**Application Number : 21/08537FU**

**Discharge of Planning Conditions 6 and 7**

Please see below our response to the comment made by the **Landscape Team on 1<sup>st</sup> November 2023.**

Title **Tree Protection Plan**

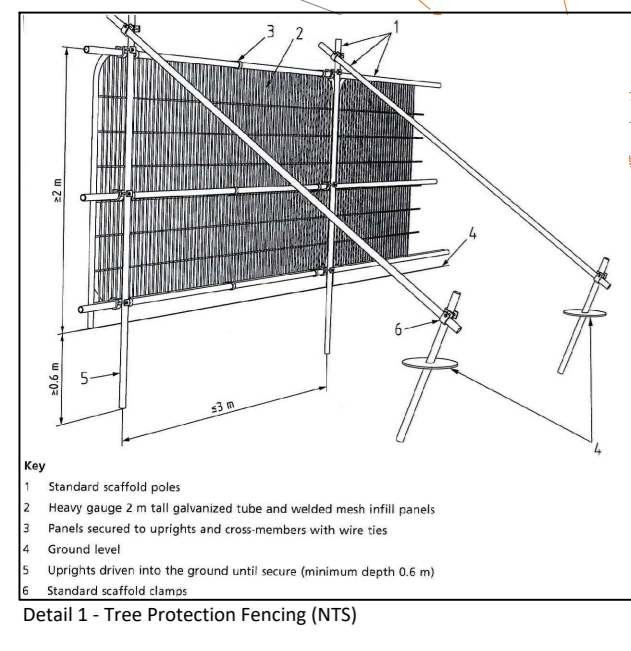
1. **The revised plan no longer illustrates the ‘default’ protection fence system** – Fence revised to scaffold pole system with ground driven posts to prevent movement.
2. **Ground protection should be illustrated within the root protection areas that occupy the driveway entrance** – This has now been mentioned in TPP01 Rev D. Also shown in photographs
3. **TREE PROTECTION PLAN should illustrate tree numbers and the AMS should include an ‘on-site monitoring schedule** – Both shown on TPP01 Rev D
4. **Photographic evidence provided should label trees and indicate the direction and location of the image taken** – Photographs of numbered trees including a key of where photo was taken from included.

Title
Hard and soft landscape proposals

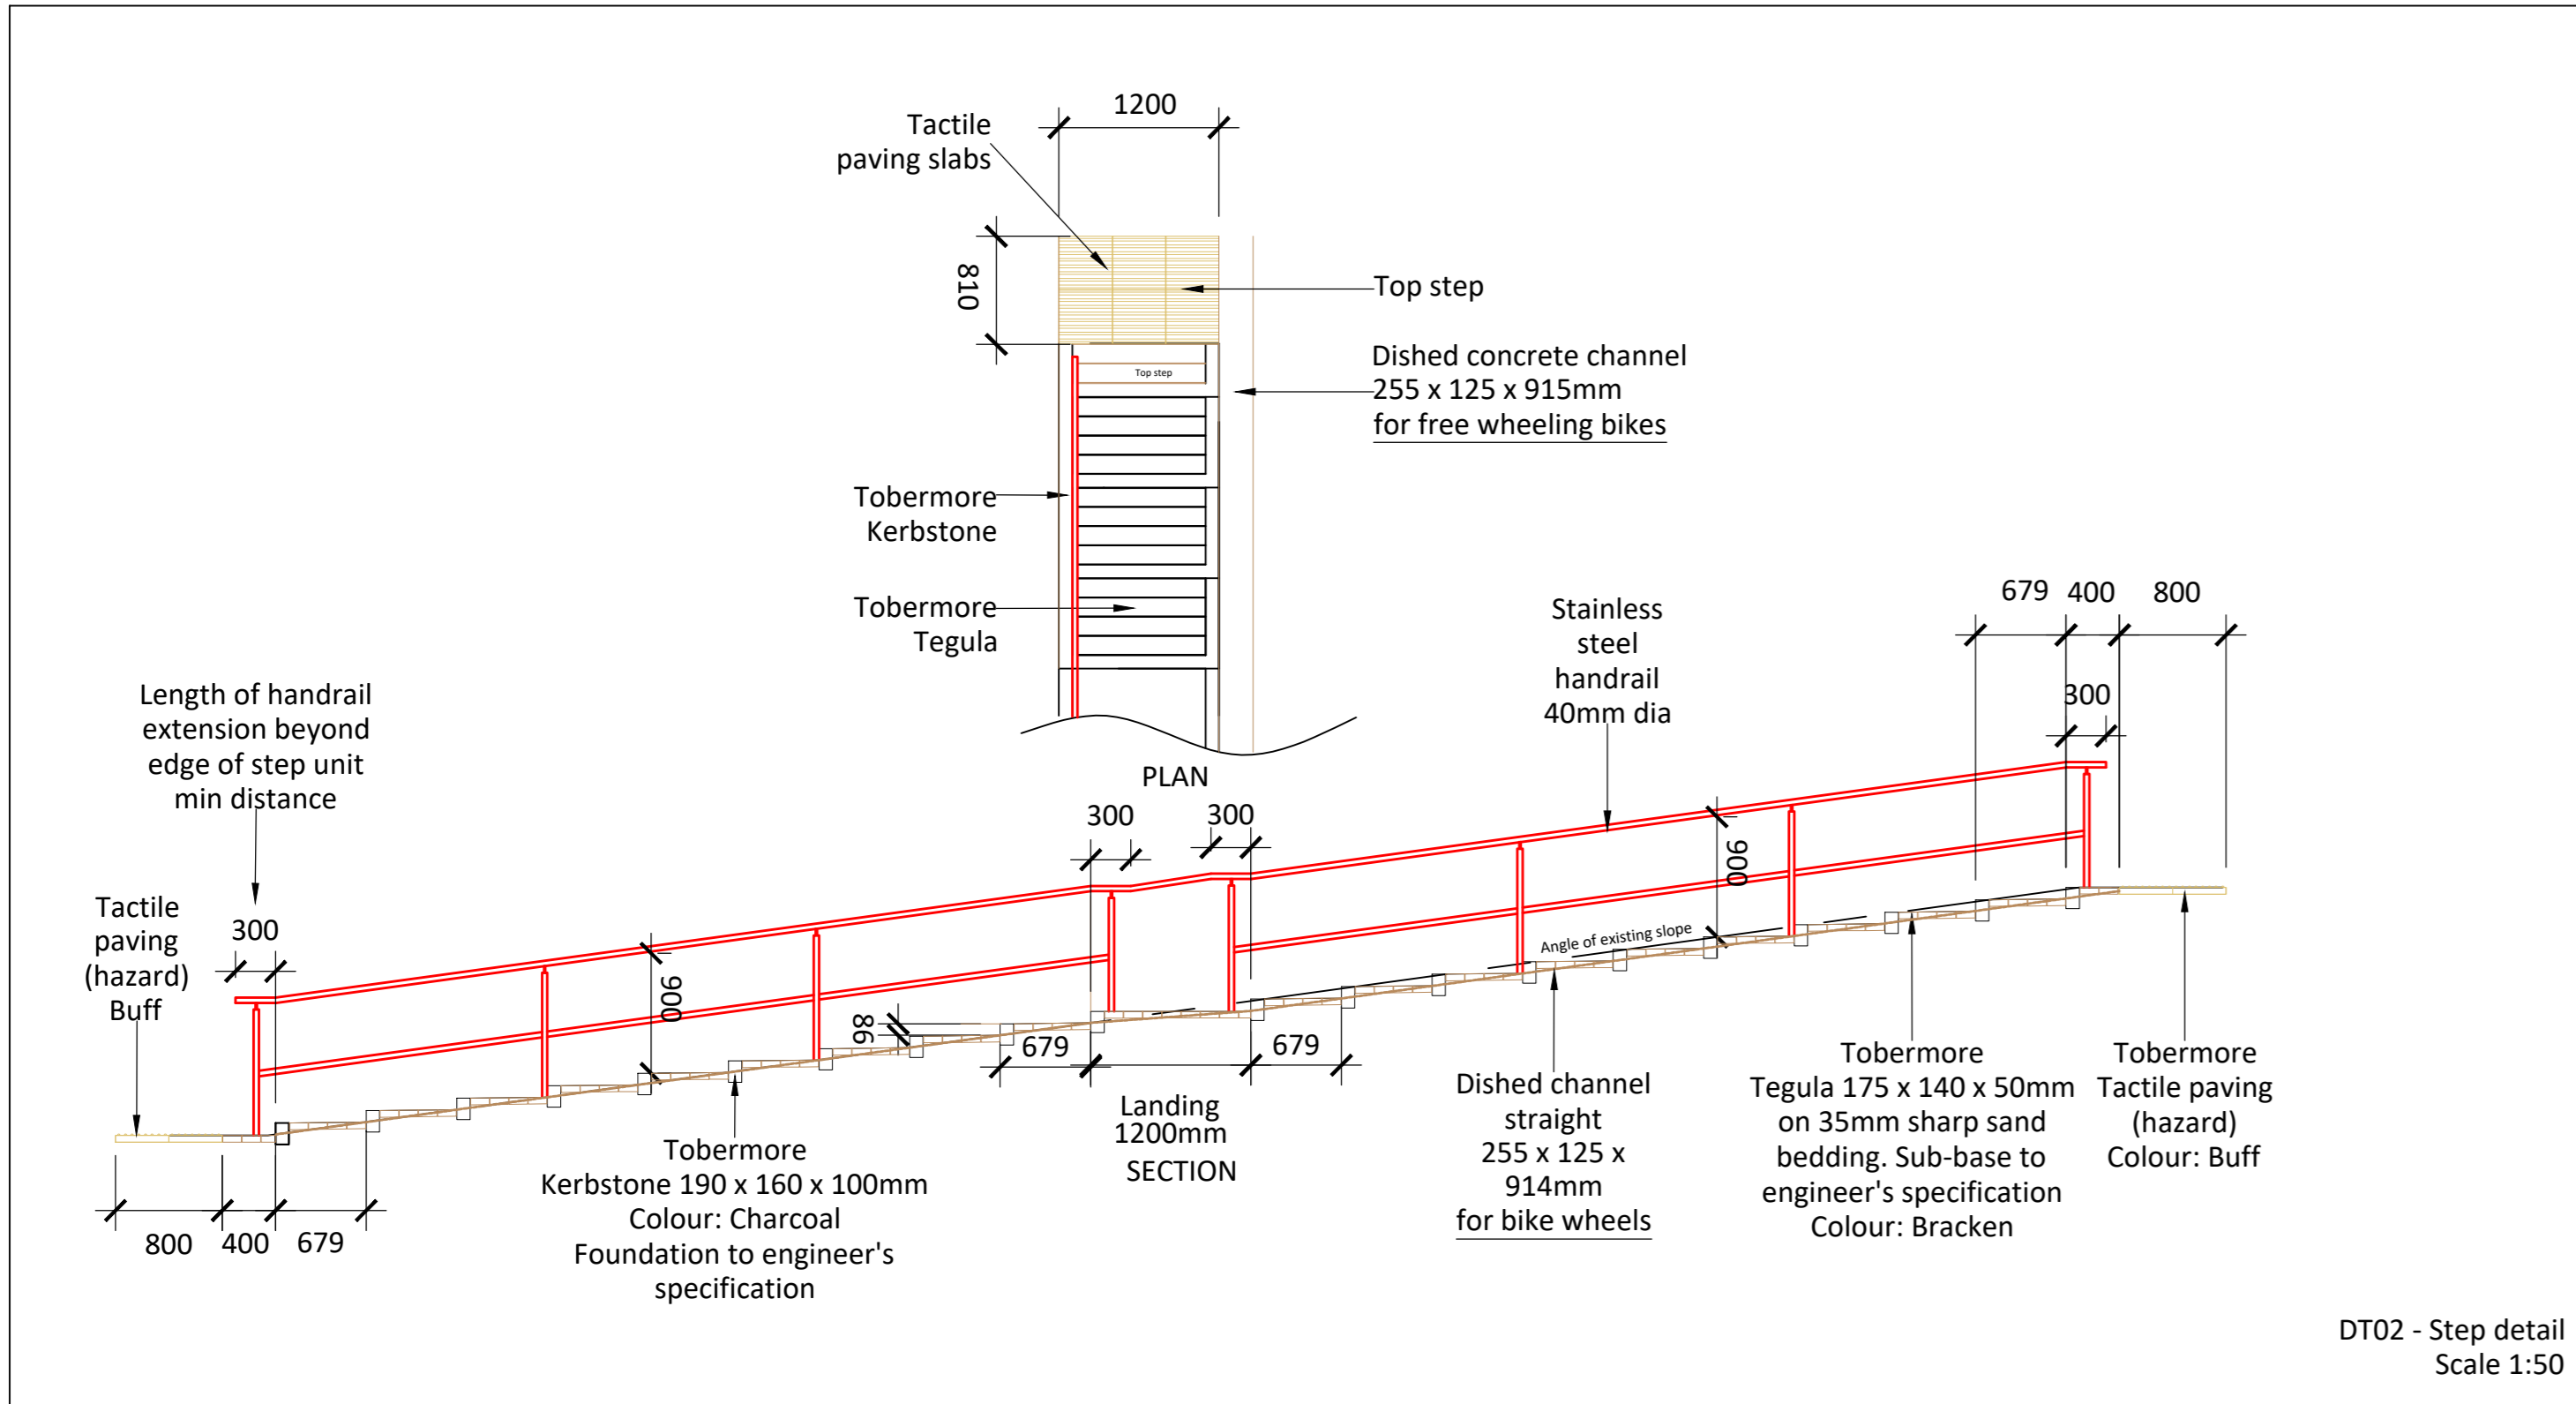
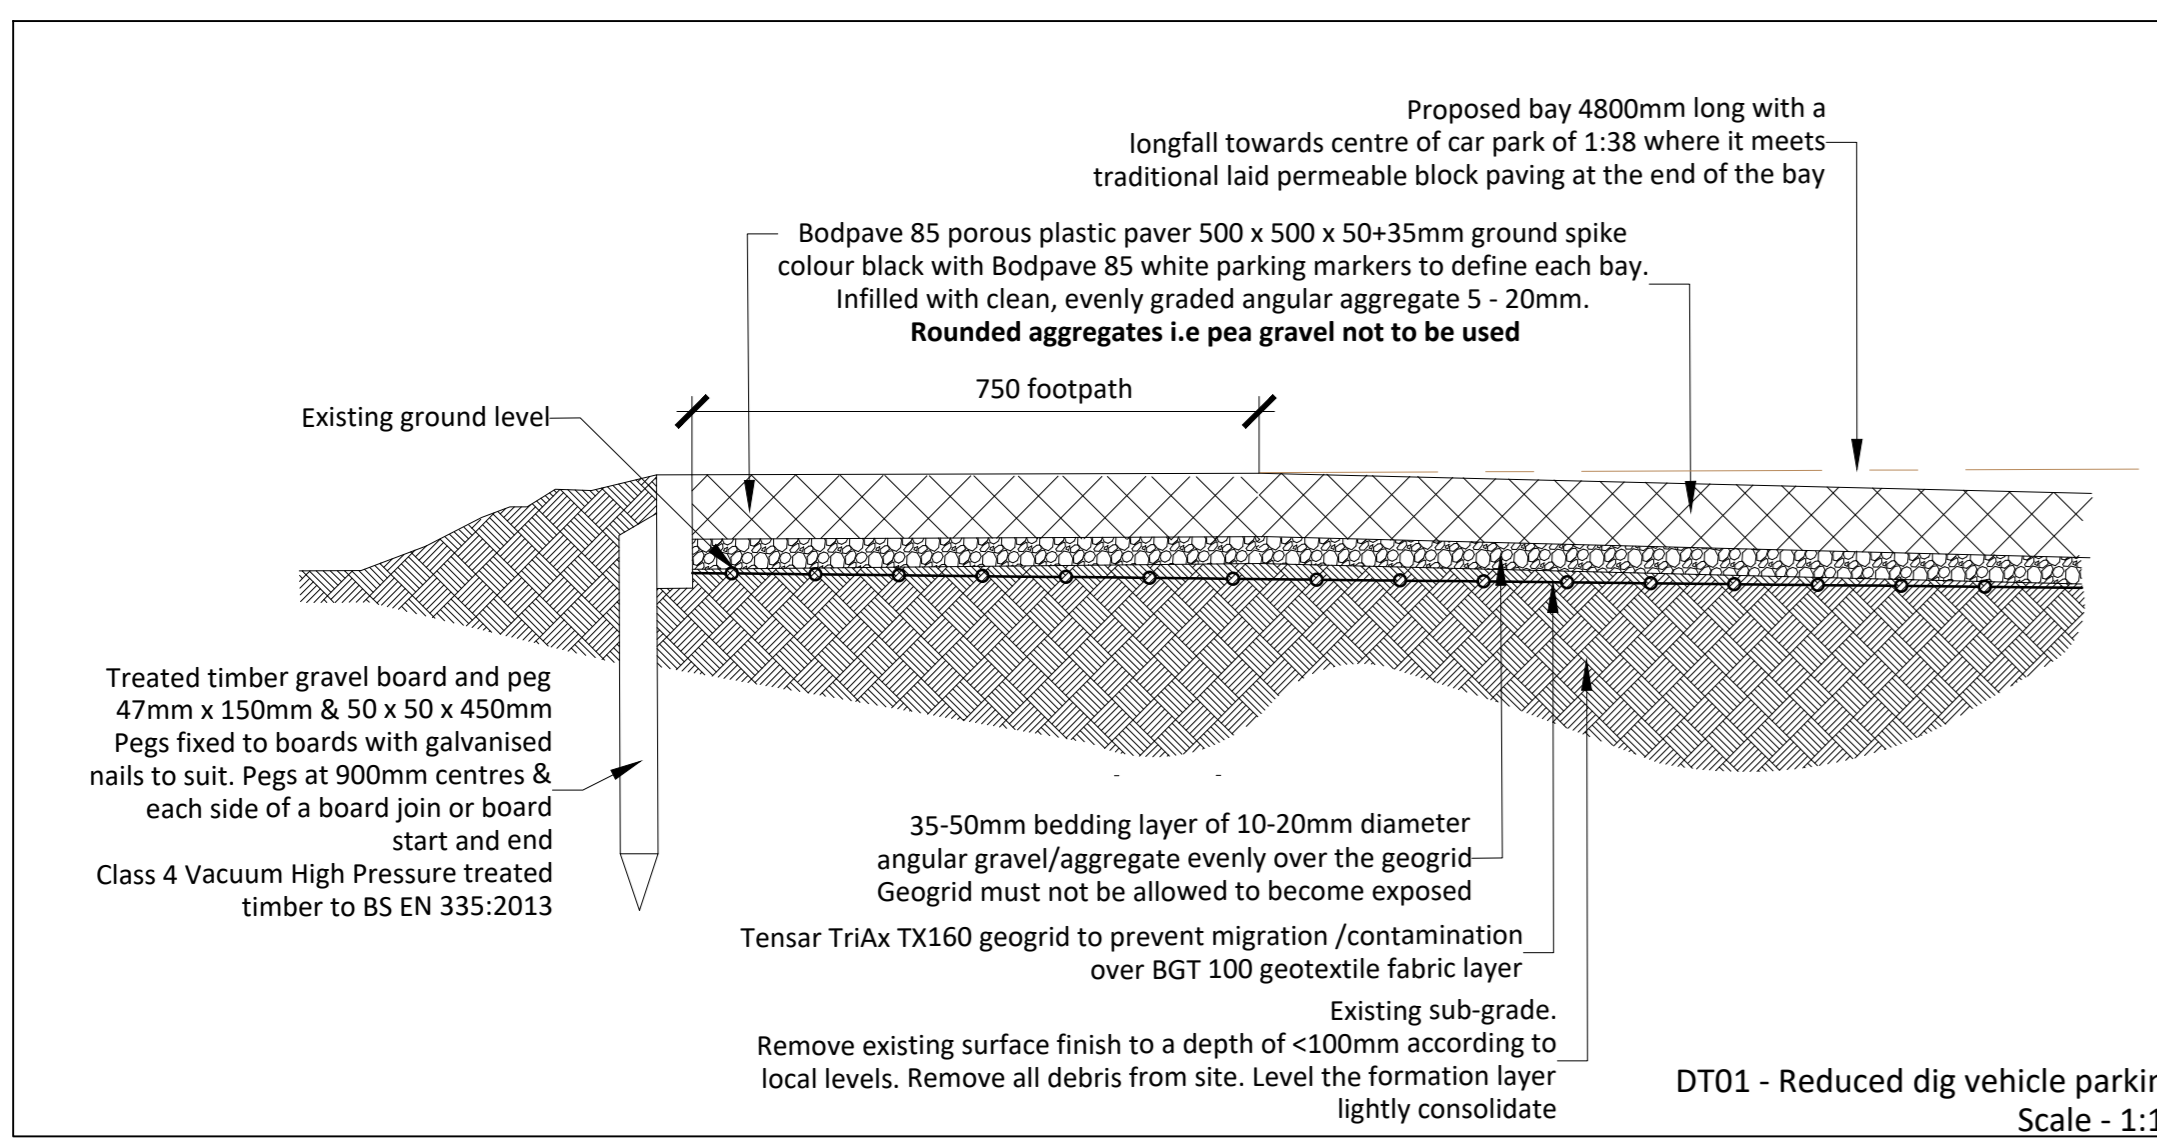
1. **HARD DETAILS relating to proposed steps do not illustrate widths** – Width of steps now added to LL01 Rev C. Width is 1200 mm
2. **Please illustrate proposed preservative staining treatment to timber screens.** - LL01 Rev C mentions use of Tanalised Timber treatment.
3. **SOFT DETAILS should accord with the LEEDS PLANTING CHECKLIST** - All planting specification shown on LL01 Rev C
4. **Please display below ground utilities on landscape plans, provide all shrub planting densities, specify peat free compost, etc.** - Water. Electric and BT locations below ground shown. Planting specification mention as above
5. **Plans should illustrate any level changes as previously requested. Please confirm by illustrating existing and proposed levels in the vicinity of tree roots.** – Levels are marked on the plans, no change in level to the Tree Protection Area
